Rezoning Transportation Analysis

Petition Number: #2022-161

From: Jake Carpenter, PE
Jacob.carpenter@charlottenc.gov
980-221-5675

Date	Description
02-23-23	First Review (PDM)
04-20-23	Second Review (PDM)
05-24-23	Third Review (DR)
07-26-23	Fourth Review (PDM)

SHEET NO.	SHEET NAME
1 of 3	CONCEPTUAL SITE PLAN
2 of 3	TECHNICAL DATA
3 of 3	MASTER PLAN

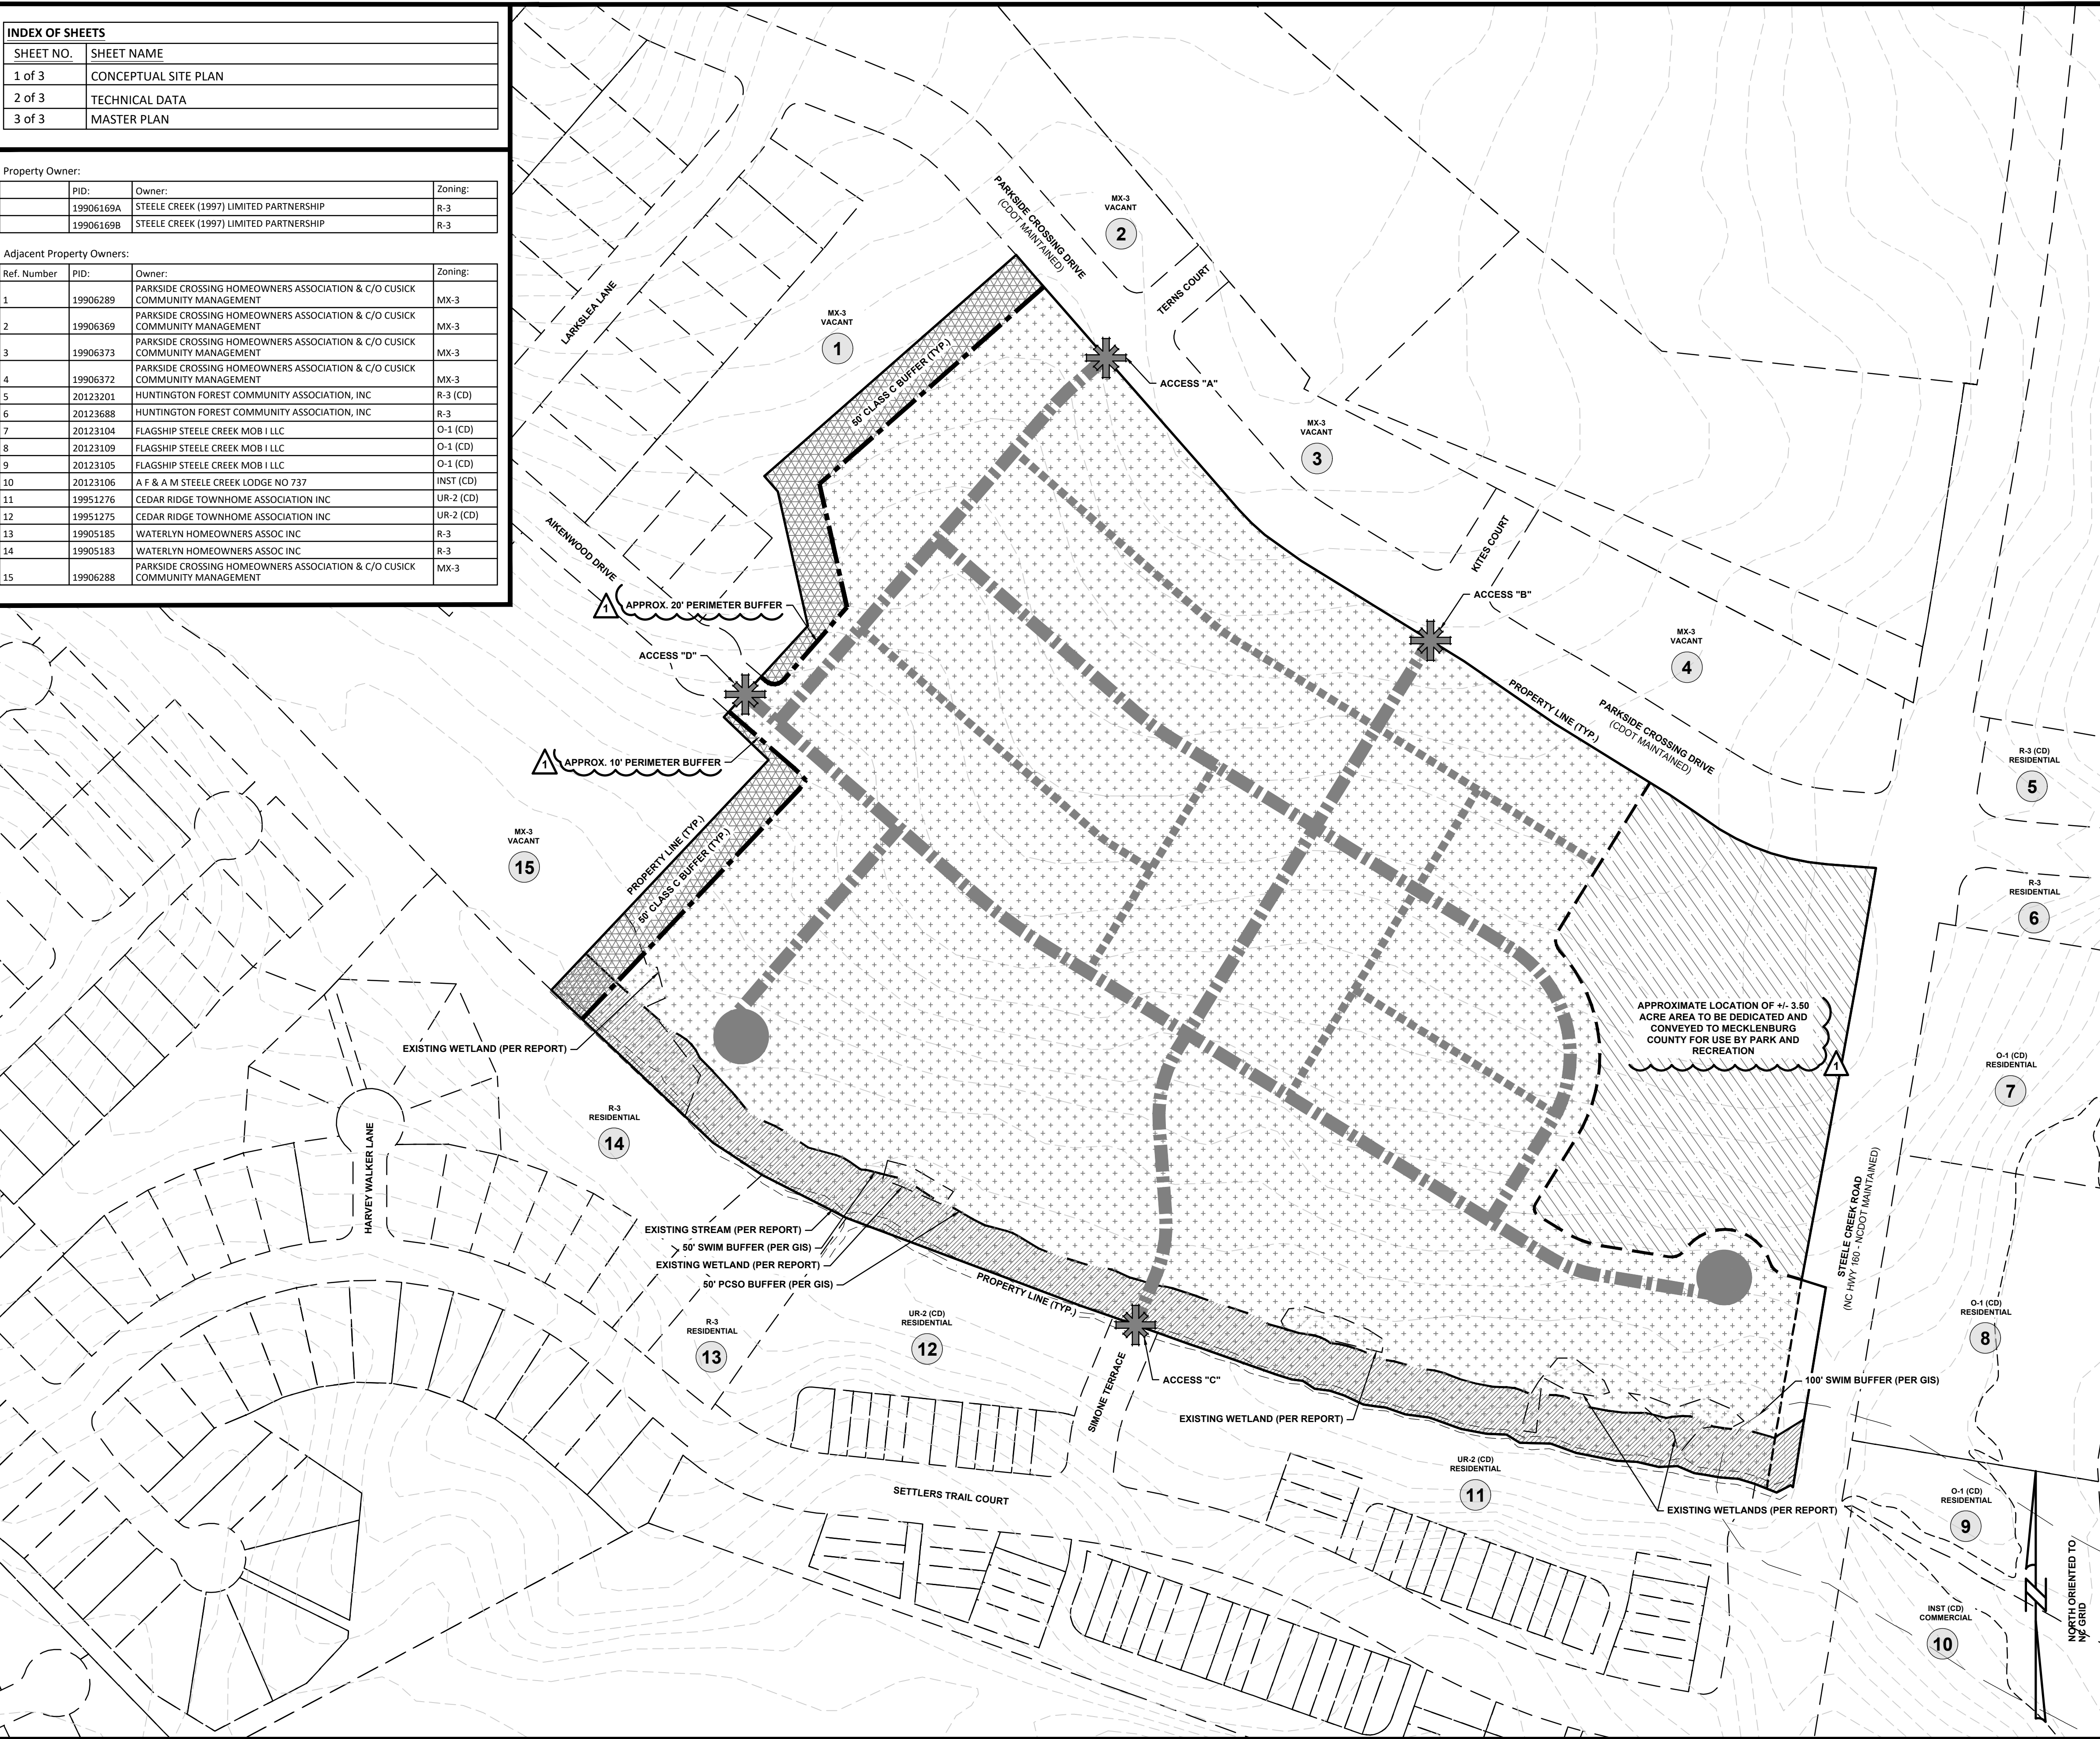
Label and dimension the curb and gutter from the centerline for each road on the site plan.

~~Update to Comment 4.20.2023: Show proposed road extension tying into Access A.~~
